CITY OF ALBUQUERQUE

November 23, 2021

Re: Champion Xpress Car Wash
1520 Juan Tabo Blvd. NE
Traffic Circulation Layout
Engineer's Stamp 11-03-21 (J20071) (J22_D031)

SITE PLAN

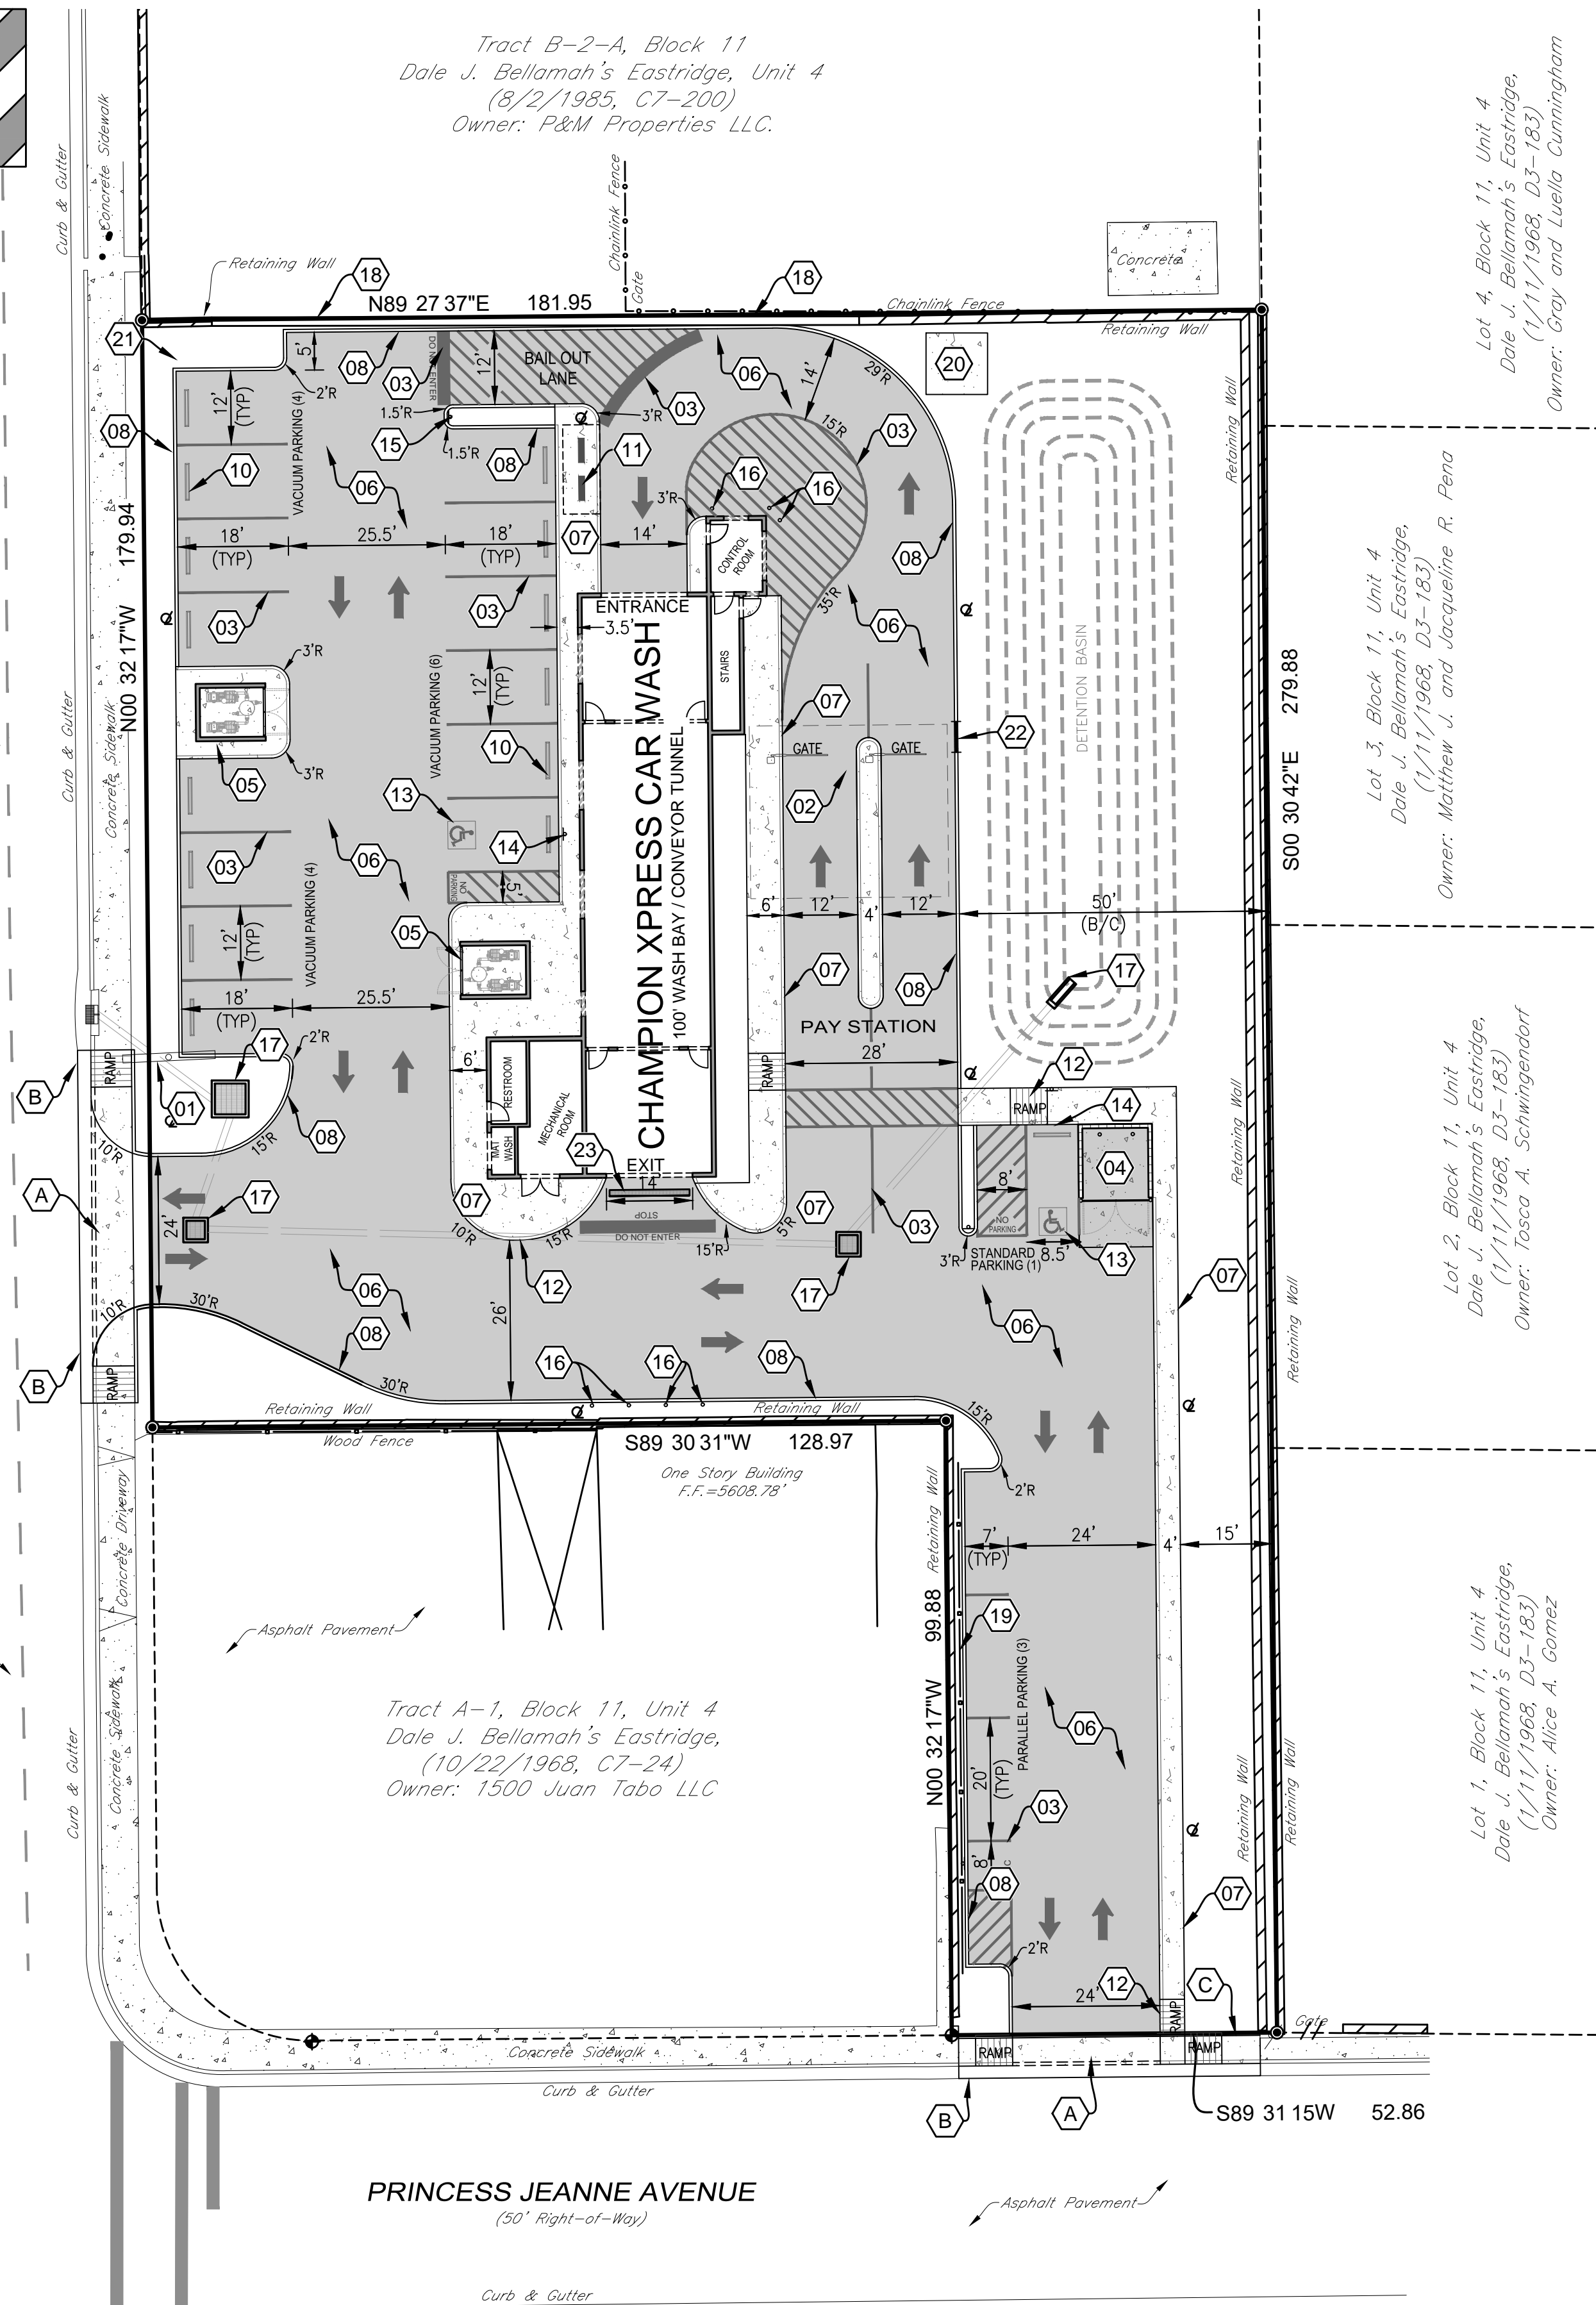
- The proposed entrance Island: why you are not allowing left turn exit?
- Southern leg driveway: Since Juan Tabo was classified as a Principal Arterial a Curb Return design is recommended.

2. Please provide the width for the ADA aisle that adjacent to the building.

3. Per the DPM, a 6 ft. wide ADA accessible pedestrian pathway is required from the public sidewalk to the building entrances. Please clearly show this pathway and provide details. This is Required.

4. Per DPM, a 6 ft. wide ADA accessible pedestrian pathway is required from the ADA parking stall access aisles to the building entrances. Please clearly show this pathway and provide details. Provide this path dimension on site plan.

5. Provide pathway dimension from bicycle racks to the building entrance.

6. Please see attached for Sight Distance. Use Intersection Sight Distance for Juan Tabo Entrance, and use Mini Clear Sight Triangle for Princess Jeanne Ave. Entrance.

7. Exit radius from car wash need to be 15' on both side.

8. Provide COA std dwg Reference for ADA Ramp, and label the slope on the landing area (which is max. 2%)

10. Provide details for all pavement markings and striping.
